August 14, 2023  
Ms. Molly McGuire  
Planner  
Community Planning and Development City of Mercer Island  
9611 SE 36th Street  
Mercer Island, WA 98040  
Re: Existing Grade Response - Permit 2207-019, Strand Residence, 6950 SE Maker Street

TOPOGRAPHIC & BOUNDARY SURVEY
PARCEL NO. 9350900620

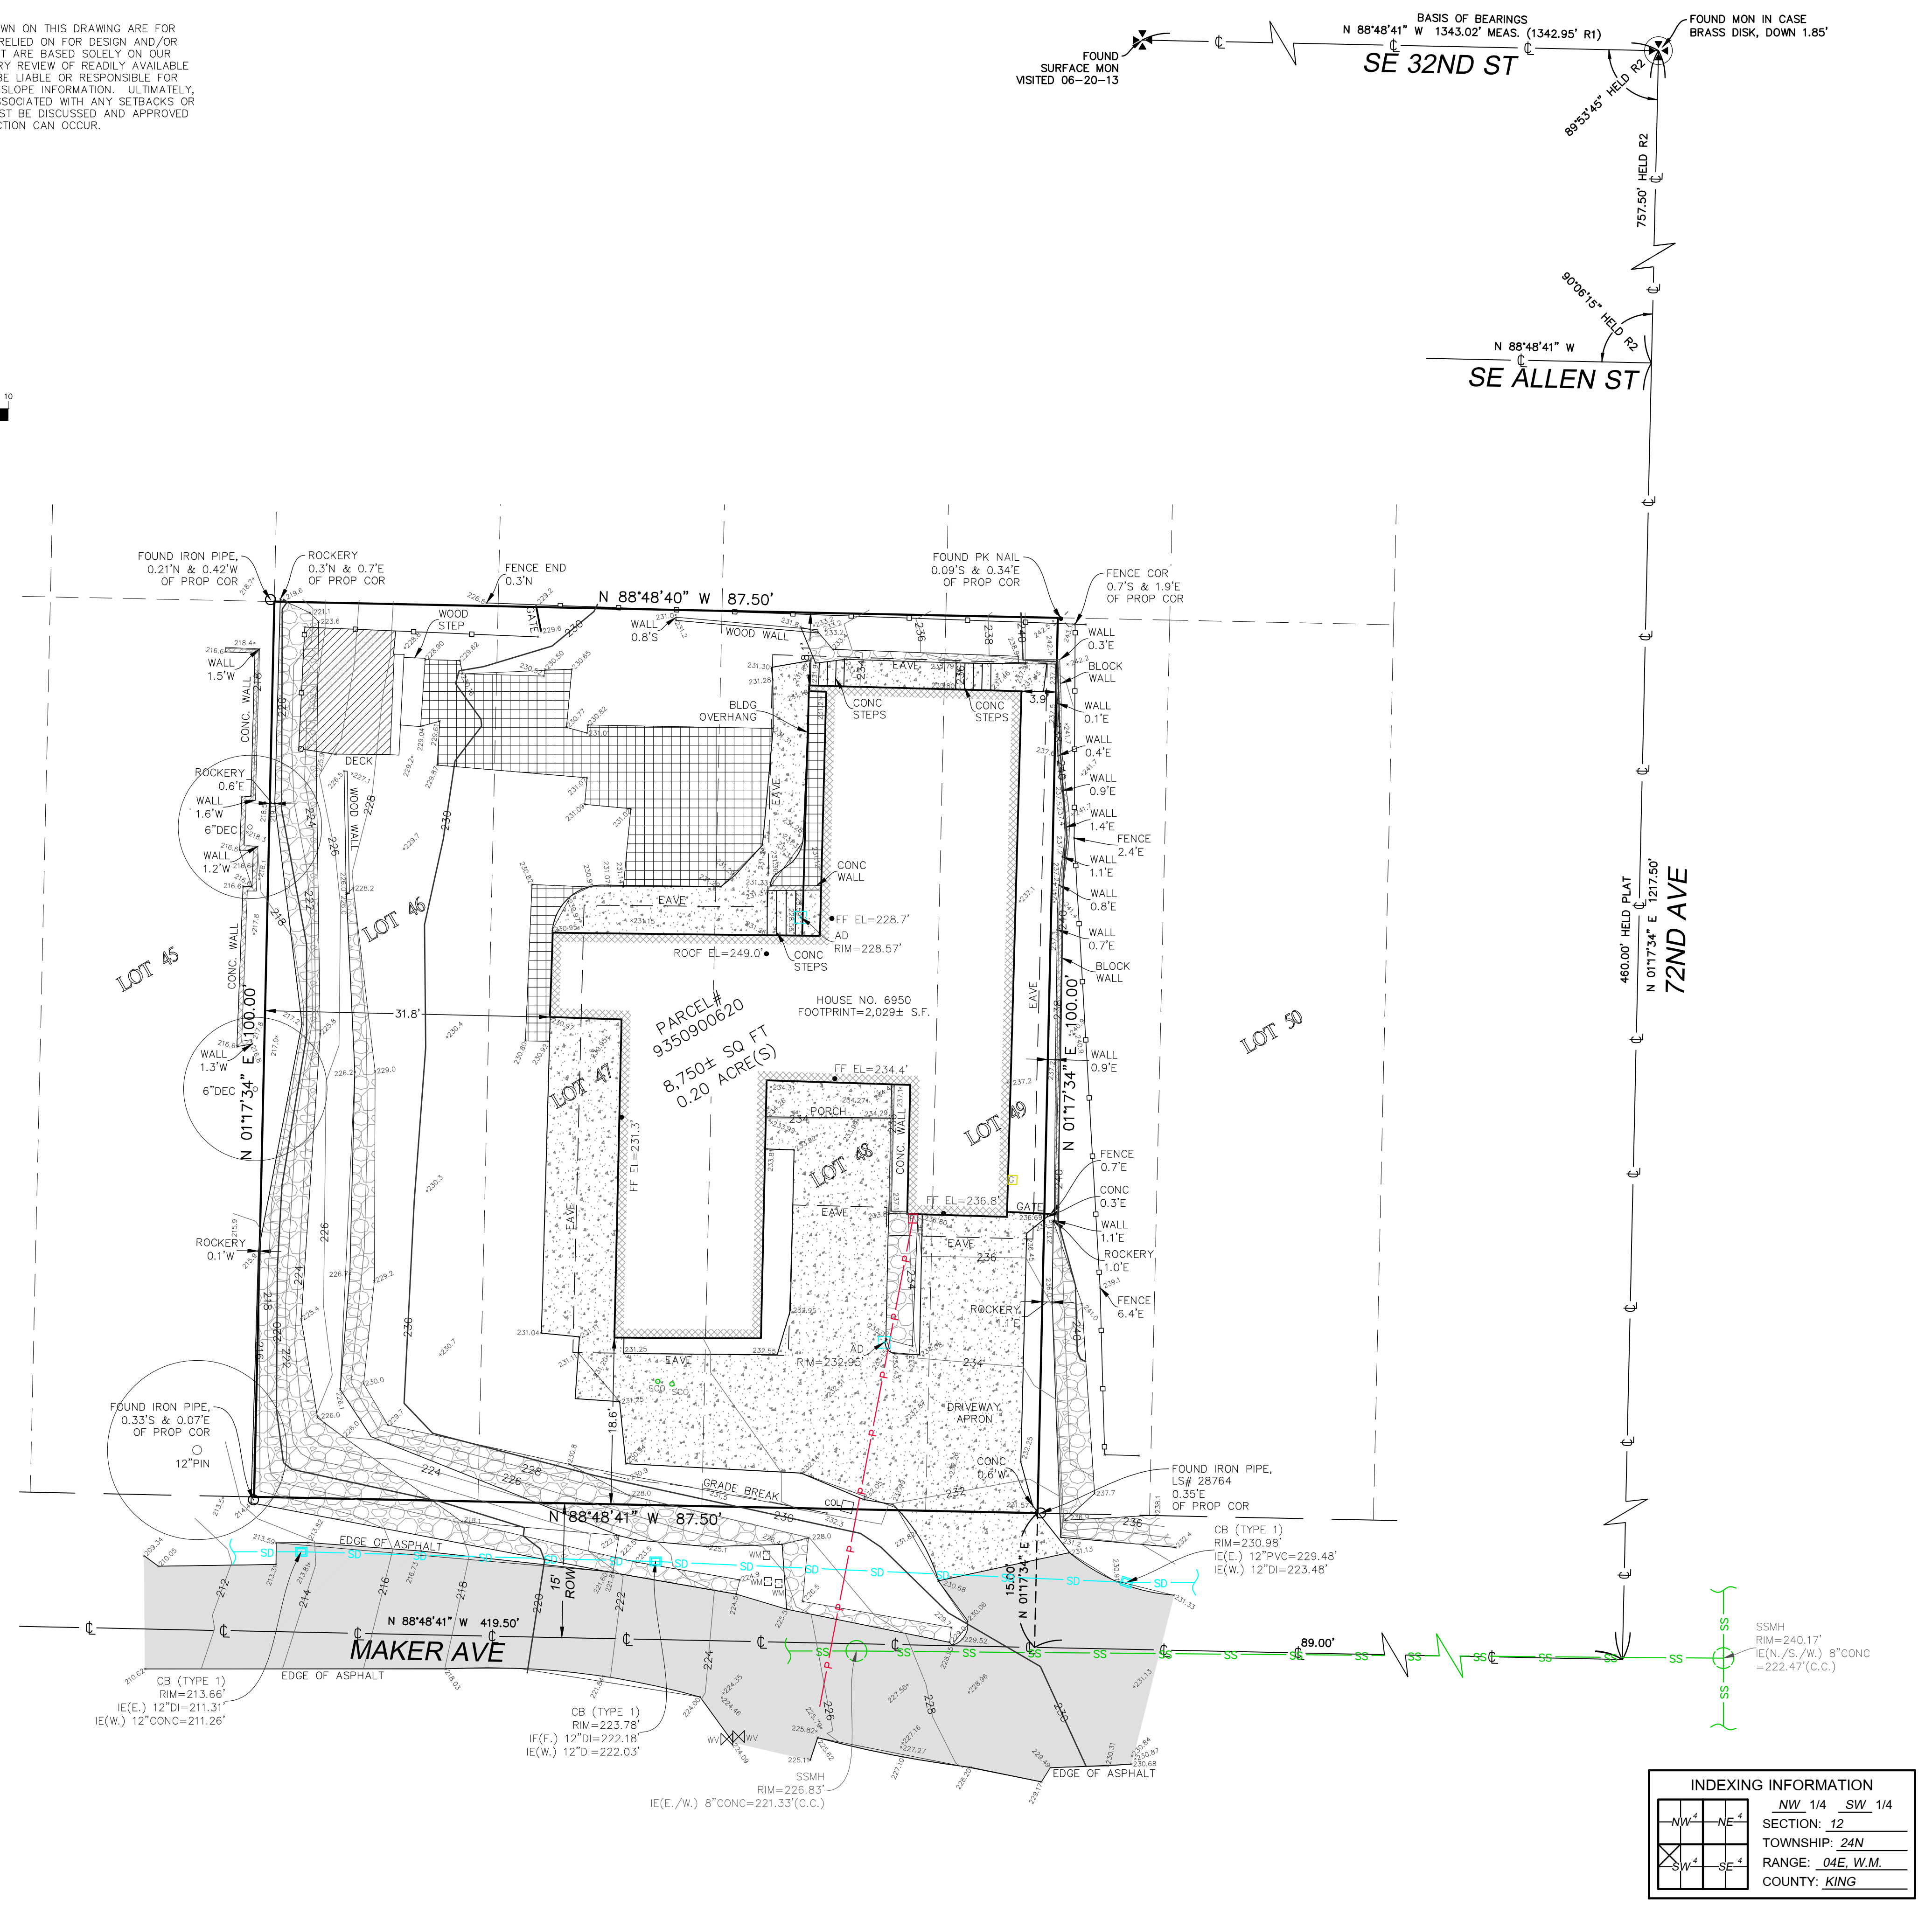
I am writing to you about the ongoing existing grade contestation by the owner's architect, project consultants, and attorney because I do not believe for one minute that they have substantiated to the City why the Terrane survey, revised 11/8/22, should be considered as *the best evidence for the original grade for the site*. Their conclusion is simply not true. And it cannot be substantiated because the truth is in the dirt as we now know - by this, I mean that the geotechnical data collected to date provides the ultimate information on the original condition of the site.

In closing, I encourage the City to continue to hold the owner and her architect accountable for meeting the existing grade requirements of the MICC and to refute the project consultant's claims that the Terrane survey stands as the best evidence for the original grade of the site.
